Online Comment

Application H16-0278-26
Location Land off Meadow Way Spalding
Proposal Demolish existing factory/warehouse to facilitate proposed residential development consisting of 230 dwellings including associated infrastructure and public open spaces.

Name Ruben Lopez Catalan
Address Lincolnshire County Council, County Offices, Newland, Lincoln LN1 1YL
LN1 1YL

Date Submitted 15-09-26
For/Against Comments

Figure 2: Trench location plan superimposed over geophysical interpretation (Magnitude Surveys 2025)

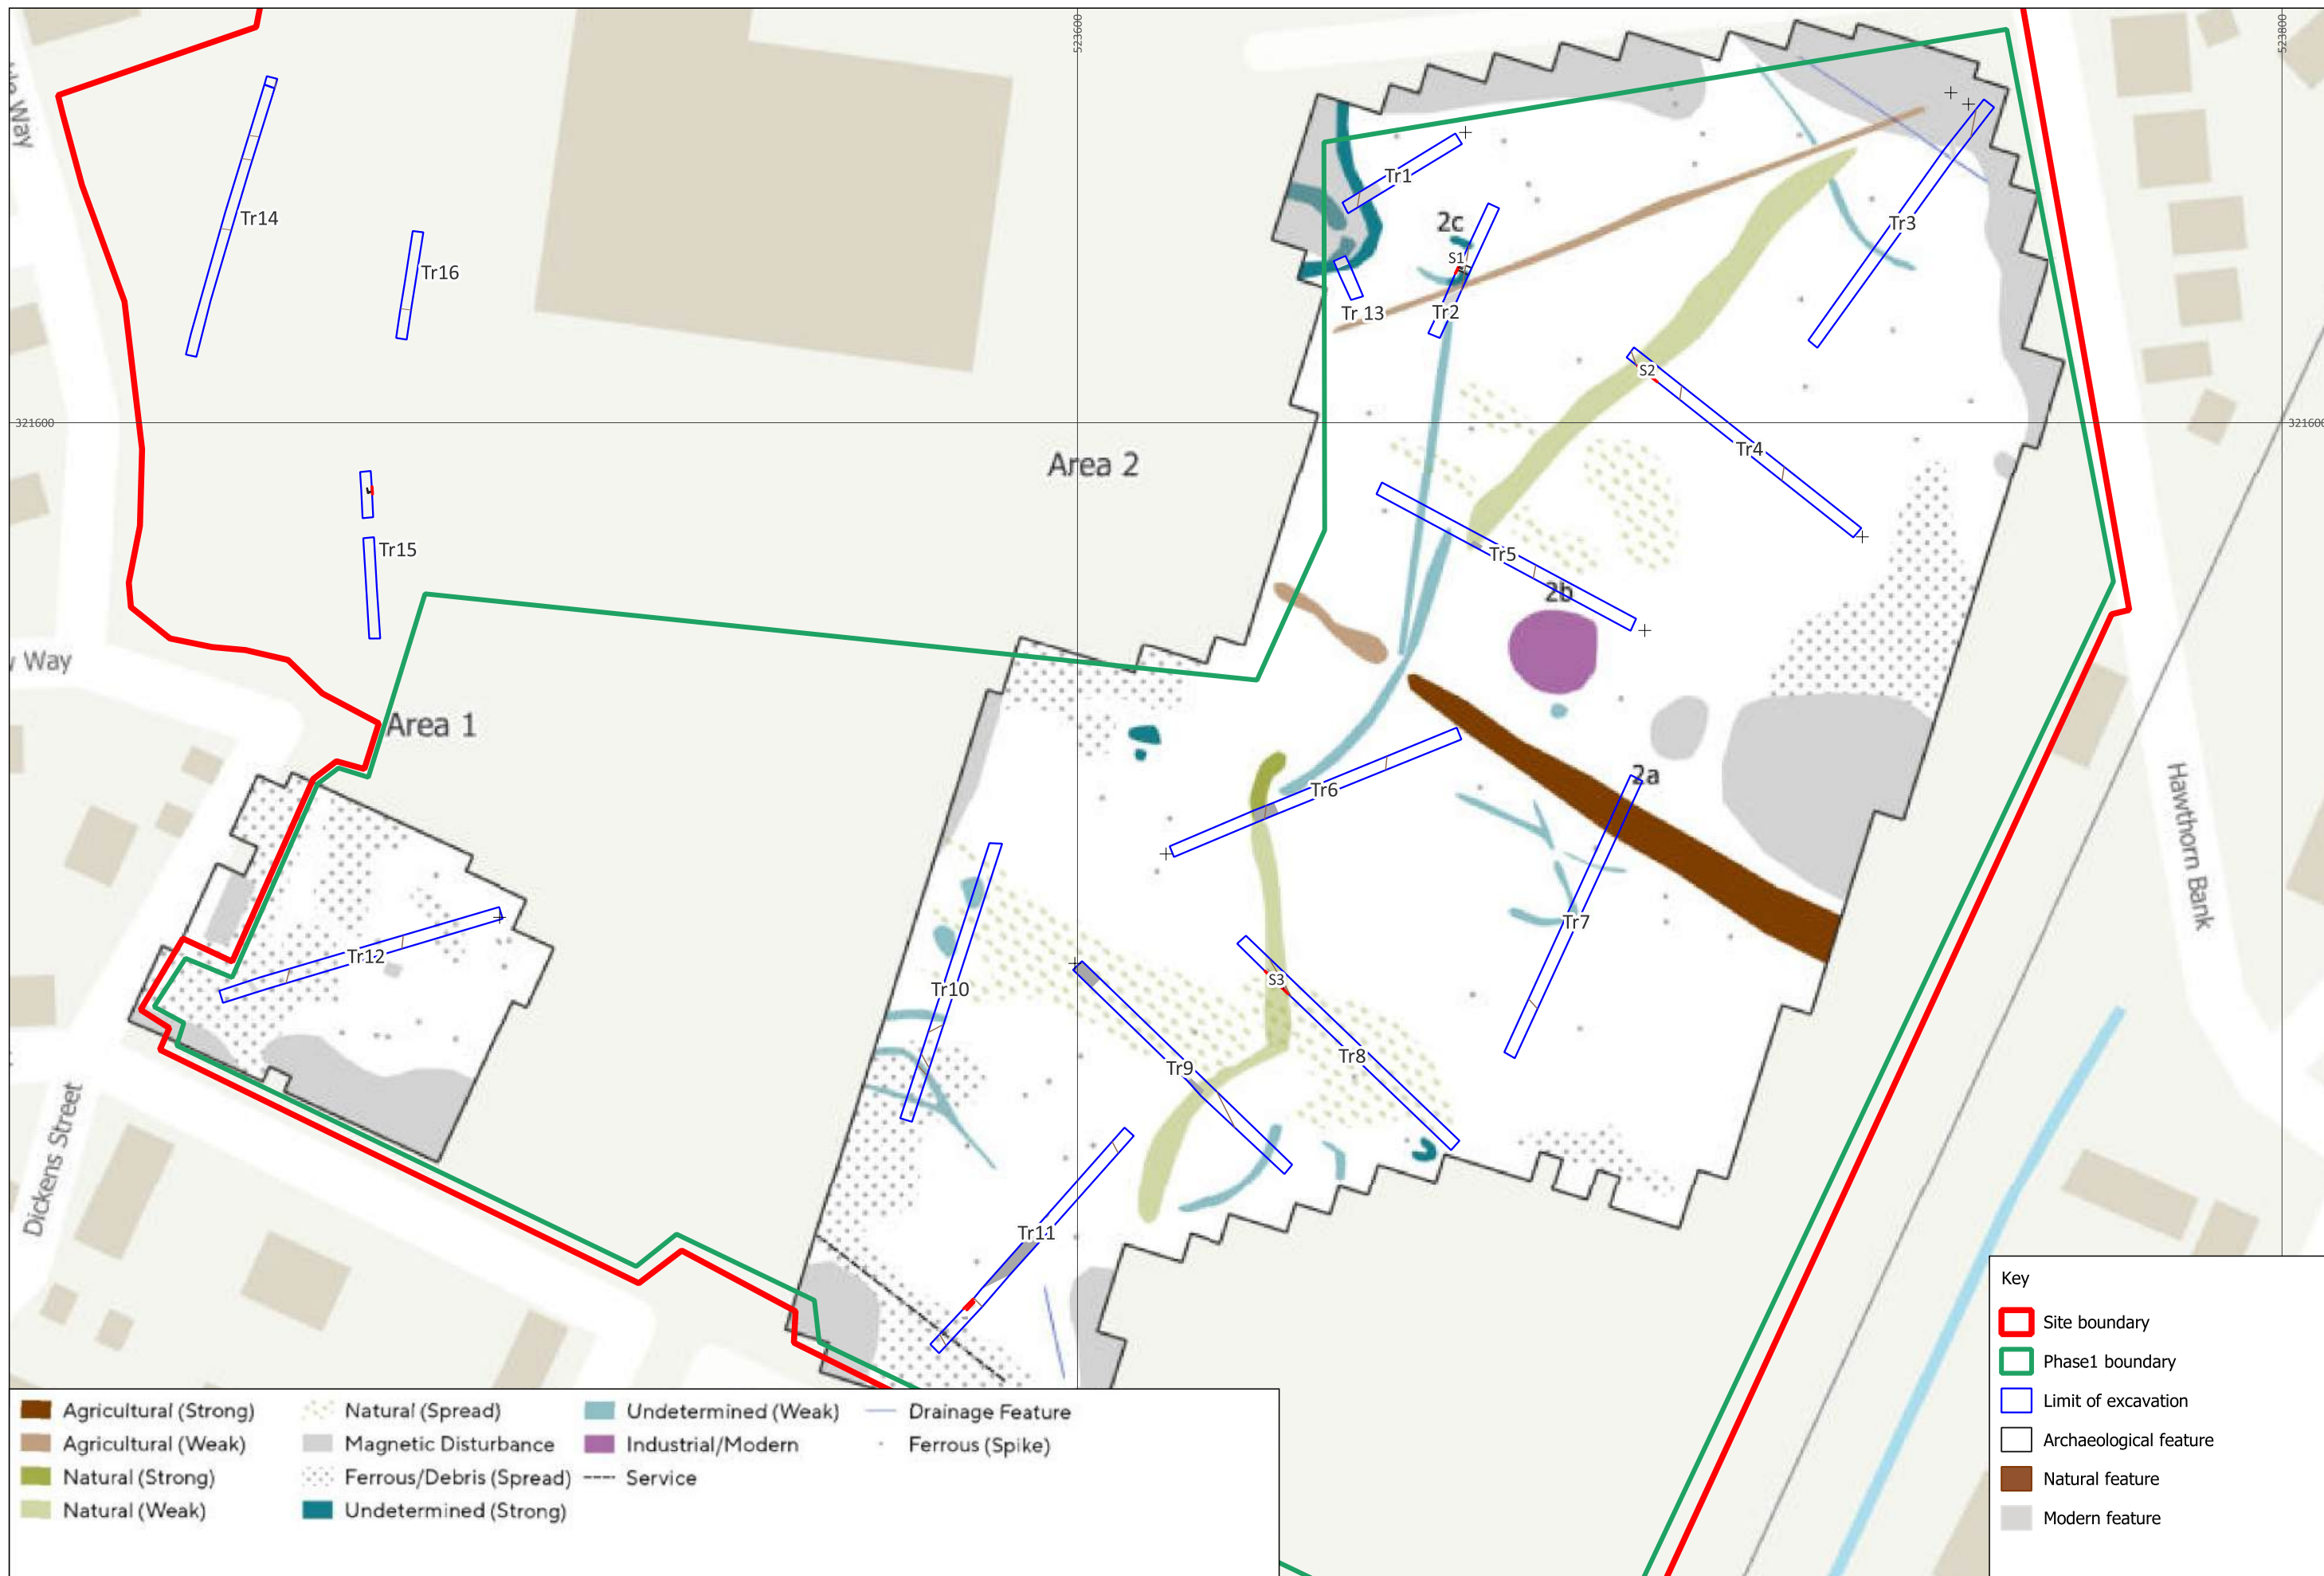
It is noted that additional archaeological trial trenching has now been undertaken within Phase 1 of the proposed development.

We do not consider that the results of the Phase 1 evaluation provide sufficient evidence to justify extrapolation to the unevaluated Phase 2 area. The extent and depth of previous limited potential truncation, and consequently the survival or otherwise of archaeological deposits within Phase 2, have not been sufficiently demonstrated through intrusive archaeological evaluation.

Moreover, the proportion of the site evaluated is below that anticipated by the agreed evaluation methodology. The trenching undertaken does not achieve the expected level of coverage across the development site.

Further archaeological evaluation is therefore required within Phase 2 to establish the presence or absence, character, depth, preservation and significance of any surviving archaeological remains.

We recommend that, if planning permission is granted, this outstanding archaeological work is secured by condition through a post-demolition phased programme of archaeological investigation covering those areas which have not previously been adequately evaluated. This should initially comprise, but may not be limited to, trial trench evaluation of the currently unevaluated areas, in accordance with the scope agreed with the archaeological consultant on 28/07/2026. The results should inform any subsequent archaeological mitigation required.
